## Fire Marshal Division

Re: Harnett Transit  
9029 US 401 N.  
Fuquay-Varina, NC 27526

### Application Number BCOM1912-0001

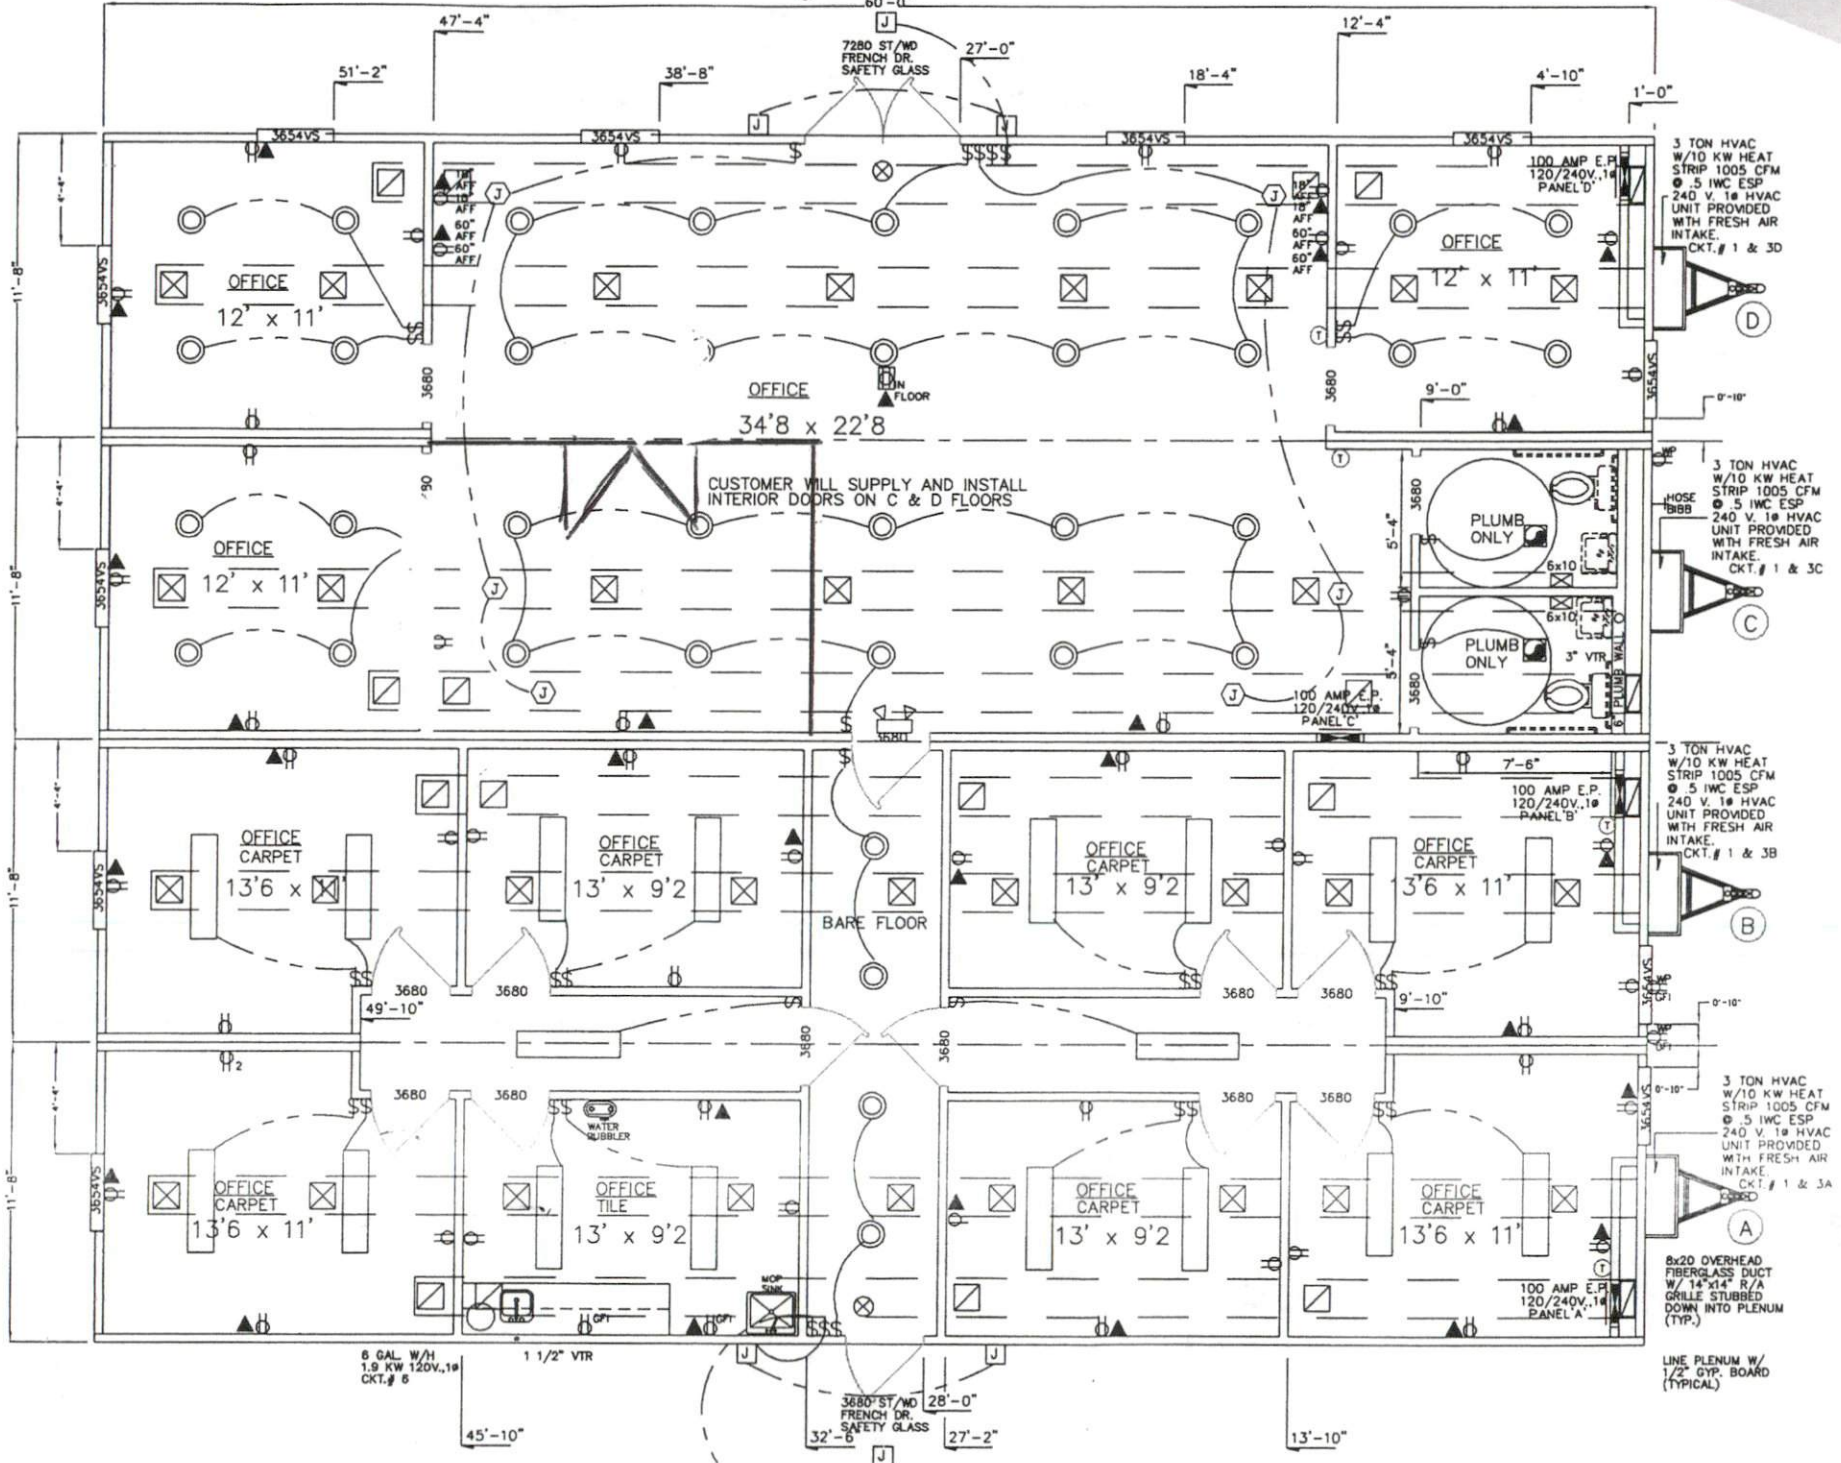
- Fire extinguishers are to be mounted no higher than 5' above the finished floor.
- **1006.1 Illumination Required**
  - The exit discharge shall be illuminated at all times the building spaces served by the means of egress is occupied, the front exit doors not indicate this requirement on the building plans.
  - Illumination level in all areas of the means of egress shall not be less than 1 foot-candle at the walking surface and shall have emergency power supply.
- **1008.1.1 Size of Doors**
  - The minimum width of each door opening shall be sufficient for the occupant load thereof and shall provide a clear width of 32 inches, the doors in the dispatch office do not meet this requirement.
- Notes
  - **A final fire inspection is required. Please contact this office direct to schedule fire inspection at 910-893-0743.**
